ATTACHMENT TO SUBMISSION FROM WILLOUGHBY CITY COUNCIL

DETAILED COMMENTS ON MODIFICATION 6 APPLICATION TO MP09_0066 THOMAS STREET CAR PARK SITE

A-0100 /B  
PRELIMINARY

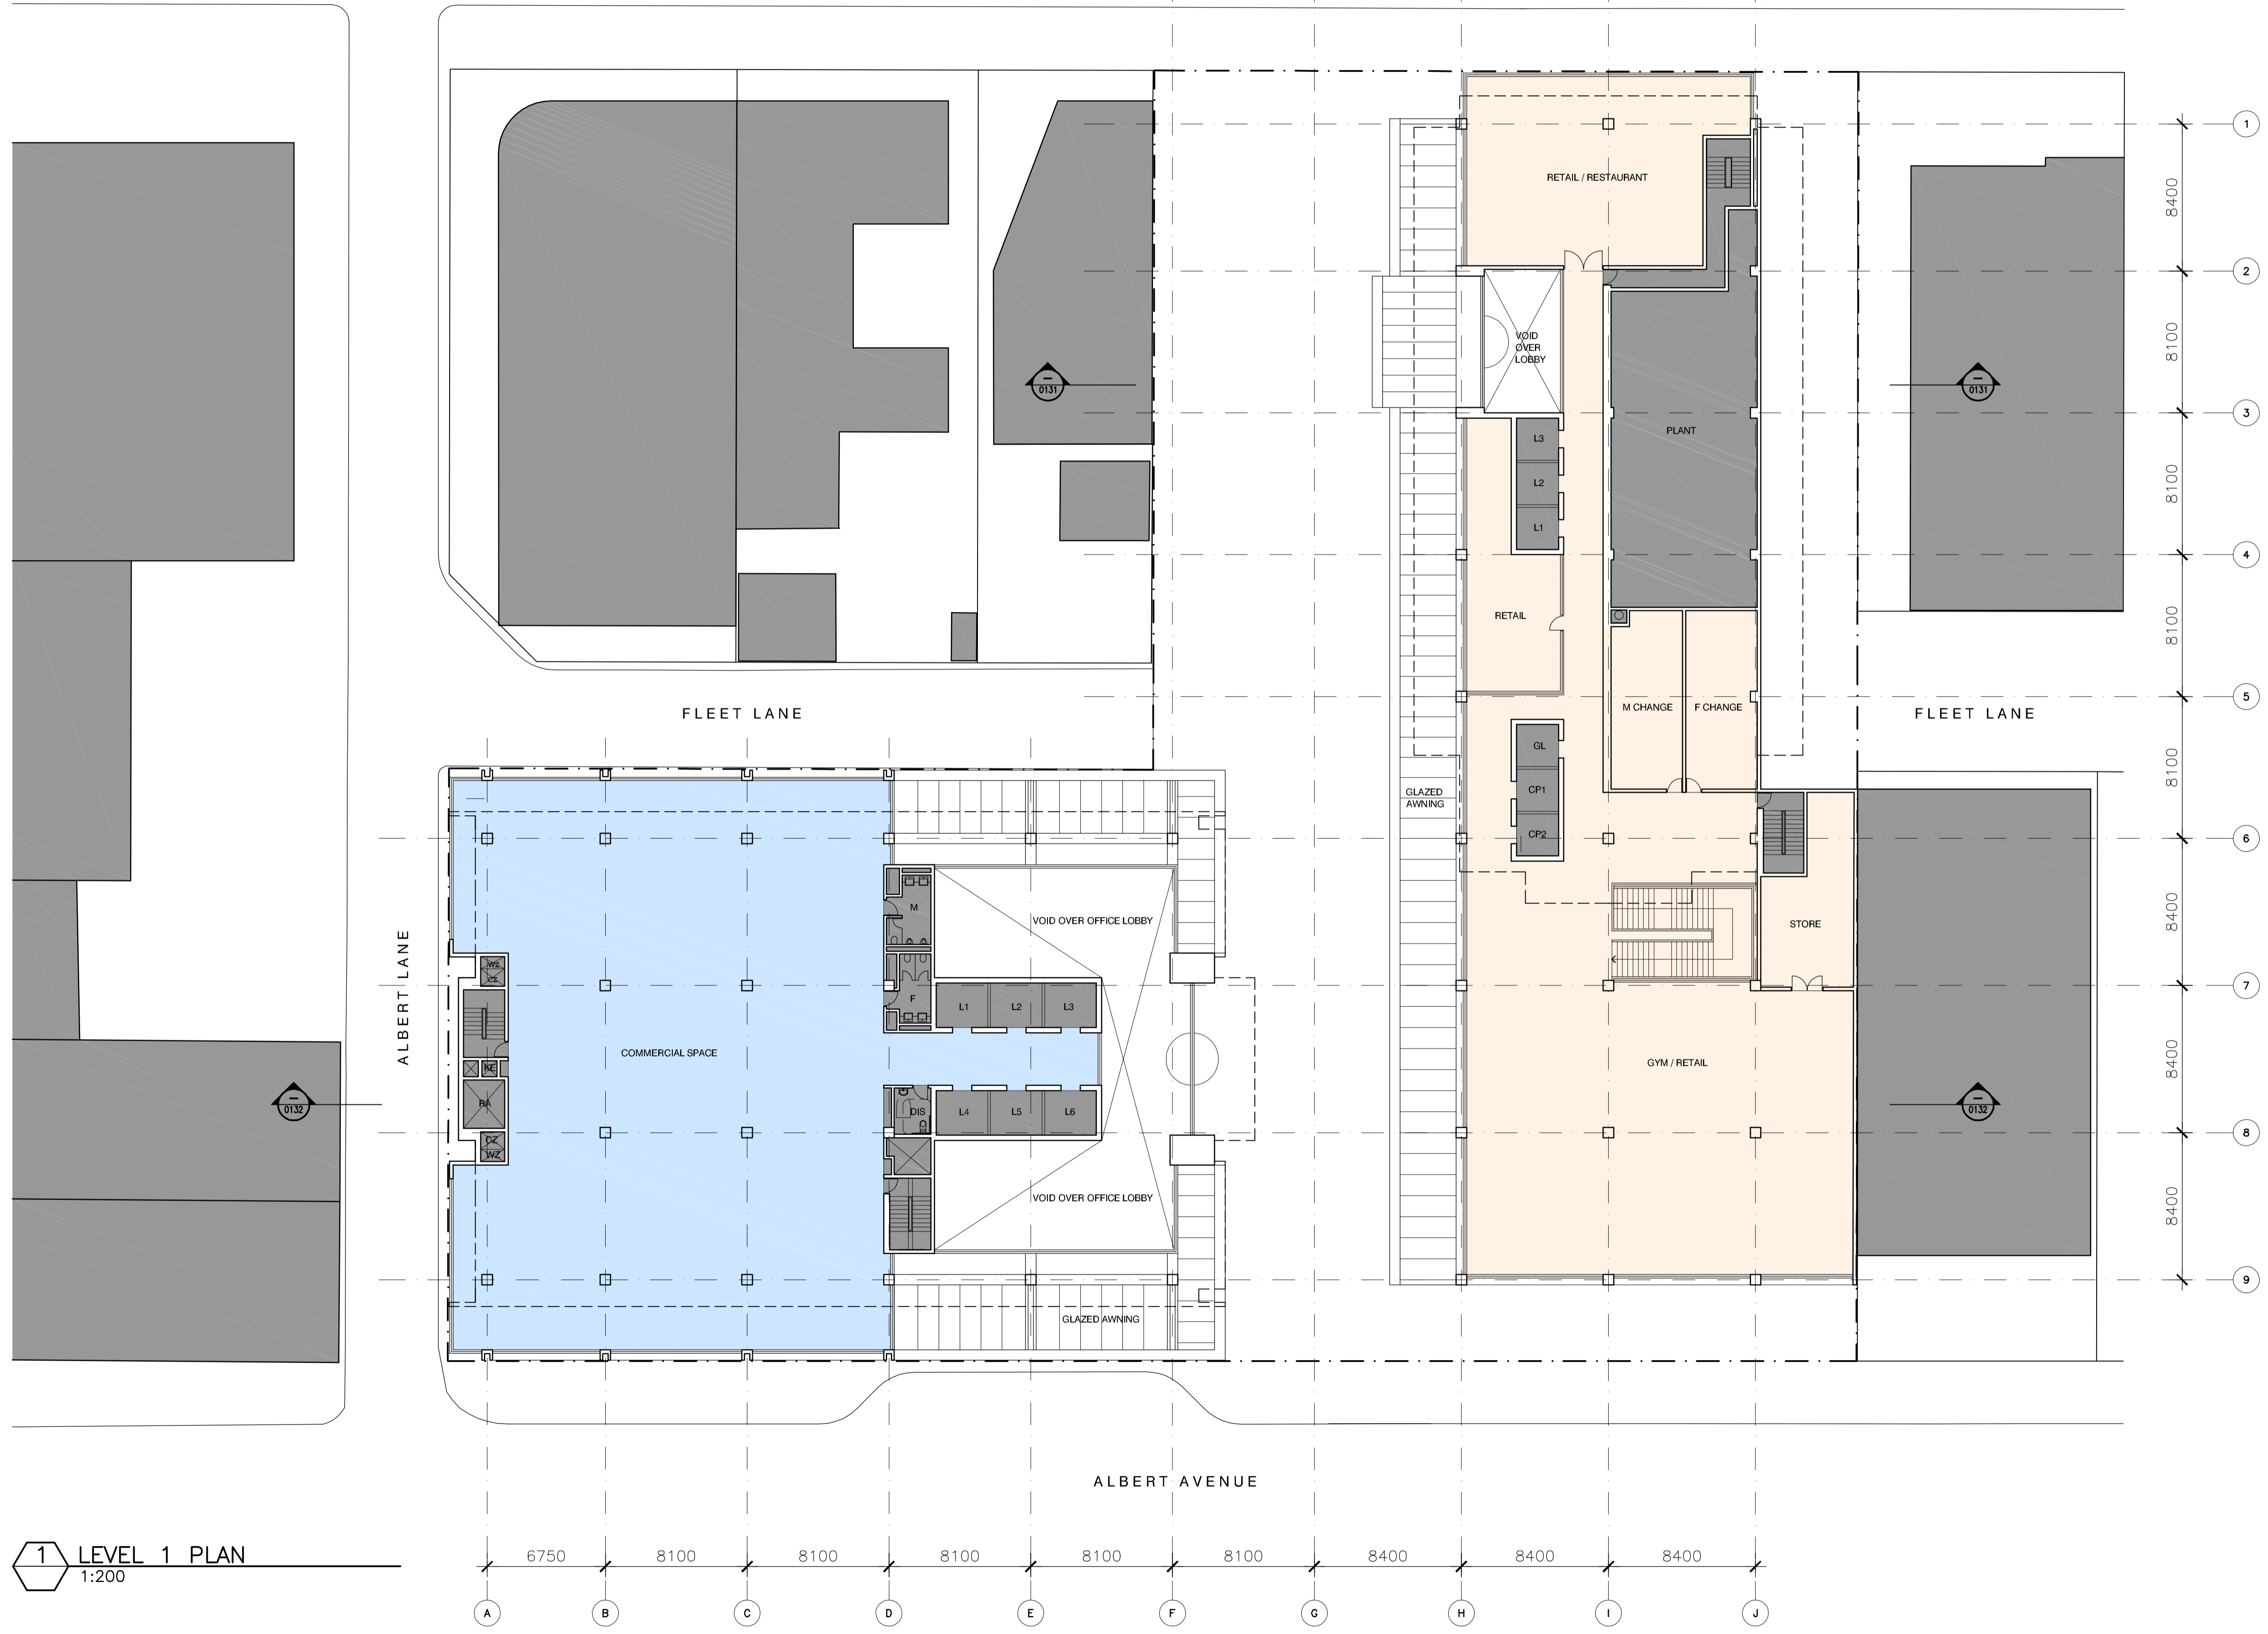
1. On Plan A-0100(d) Street Level/Ground Floor Plan the following issues apply:
 - a) The entries and exits from the car park on Thomas St show at least two entries and two exits from the car park spread over 18m length. There are concerns to pedestrian safety as motorists may not be looking out for them when exiting the site. Vehicular conflict points exist when vehicles are simultaneously trying to enter and or leave the site, particularly when exiting if one vehicle wants to turn right while the other wants to turn left. The same concerns apply for the entries and exits from Albert Ave. The array of access points is confusing and there are no refuge points within the driveway to allow pedestrians to stage their crossing. The number of entries and exits could be minimised by relocating the above ground parking levels to below ground.

- b) Advice is required as to how the entries and exits on both Thomas St and Albert Avenue are to differentiate between resident, public parking, service apartment parking, loading dock users entering the site. There is a high risk that motorists may enter the site via the wrong lanes or use exit lanes to enter.

- c) The location of where the guidance parking signs on the drawing indicating where the parking sign with number of bays available will be installed for the Council car park.
